From: Brenda Larsen
Sent: Friday, August 30, 2013 8:03 AM
To: Jeff Watson
Subject: RE: BL-13-00020 Suebert

Re: Suebert (BL-13-00020)

After conducting a review of the above named project, I have the following comments:

PROPOSED

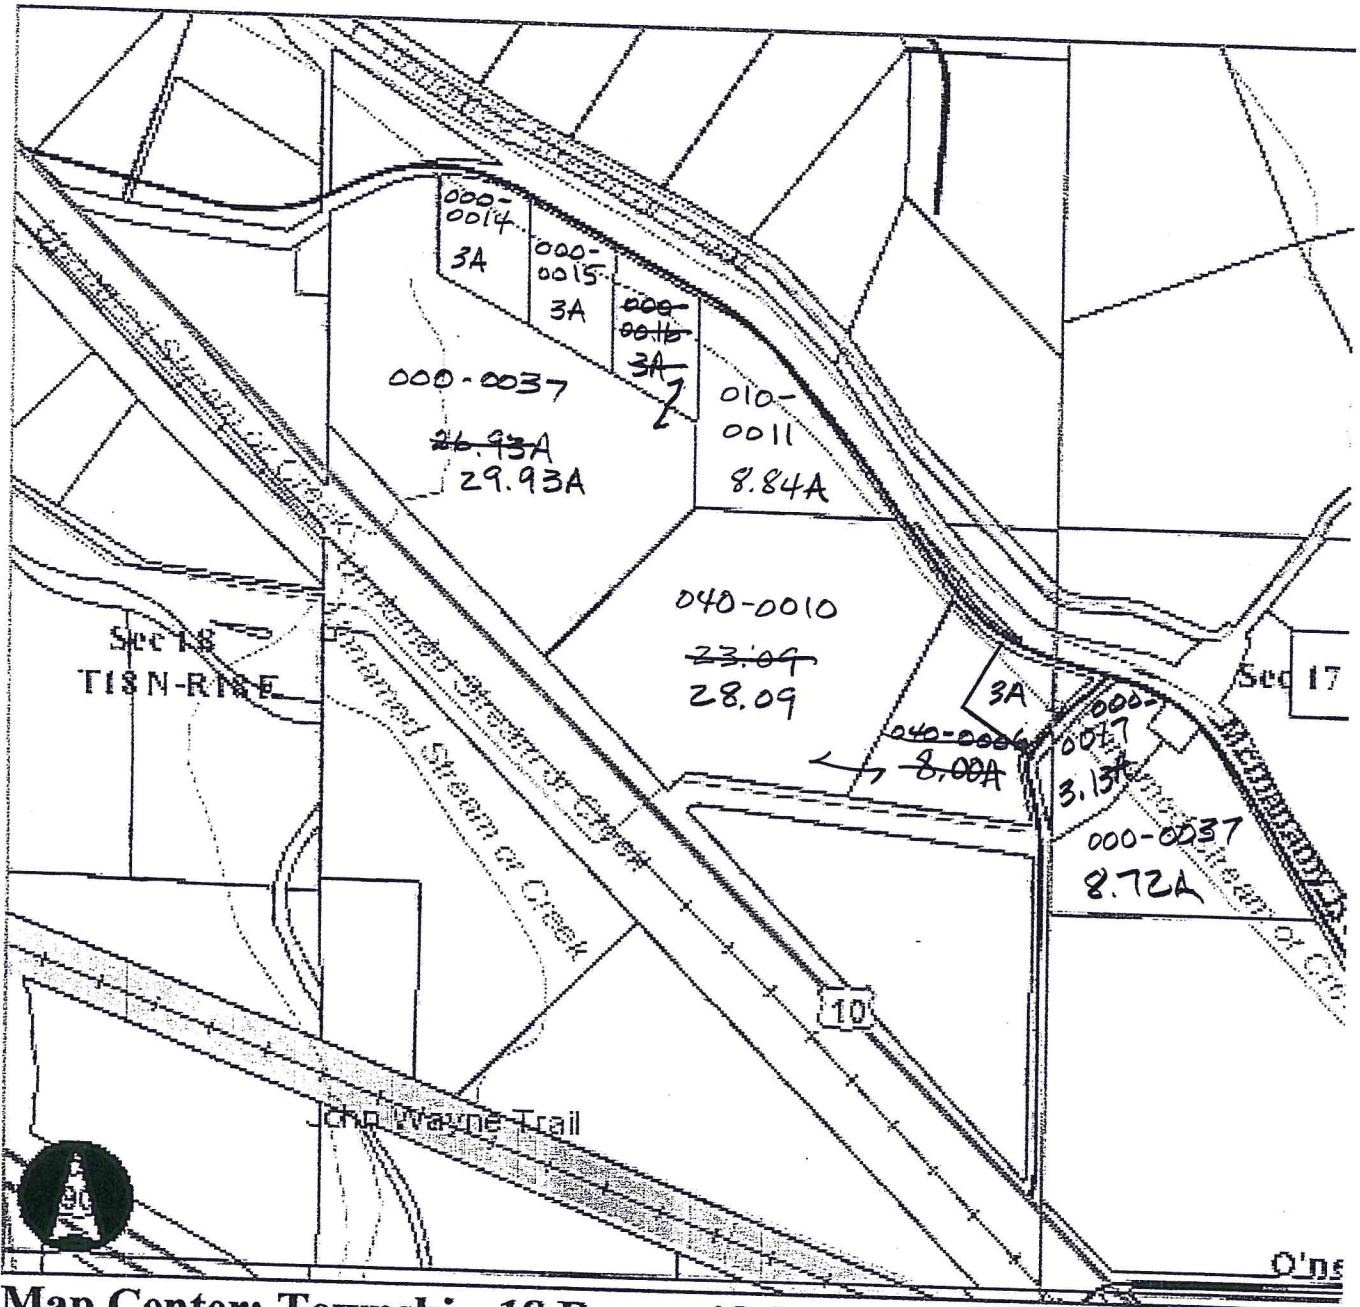
- Ensure that boundary line adjustments do not infringe upon existing structures, to include propane tanks, etc.
- Ensure adequate access for fire apparatus. Any driveways or access points created based off the new lot configurations shall comply with Kittitas County Code 20.02.030.
- All future development must comply with the International Fire Code.
